Your ref: 3/2016/0034
Our ref: DC/16/371
Date: 15-FEB-16

Location: Land adj to 2 Harewood Avenue, Simonstone
Proposal: erection of 1 dwelling

LOCATION & SITE PLAN  
 OF  
 LAND AT 2 HAREWOOD AVE  
 SIMONSTONE  
 FOR  
 MR & MRS M LANGLEY

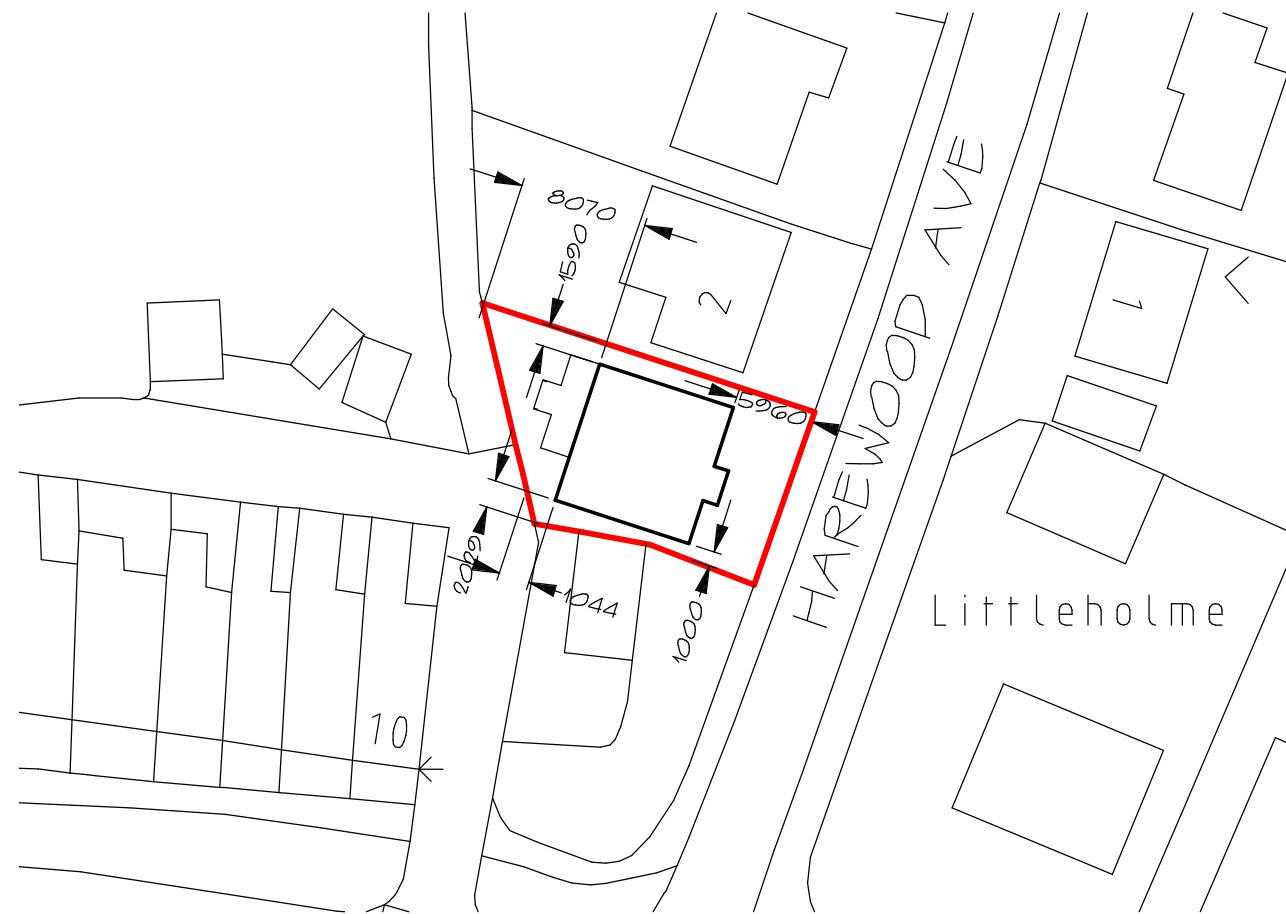
A public sewer crosses this site and we may not permit building over it. We will require an access strip width of six metres, three metres either side of the centre line of the sewer which is in accordance with the minimum distances specified in the current issue of "Sewers for Adoption", for maintenance or replacement. Therefore a modification of the site layout, or a diversion of the affected public sewer at the applicant's expense, may be necessary. To establish if a sewer diversion is feasible, the applicant must discuss this at an early stage with our Developer Engineer at wastewaterdeveloperservices@uuplc.co.uk as a lengthy lead in period may be required if a sewer diversion proves to be acceptable.

Deep rooted shrubs and trees shall not be planted within the canopy width (at mature height) of the public sewer and overflow systems. Trees should not be planted directly over sewers or where excavation onto the sewer would require removal of the tree.
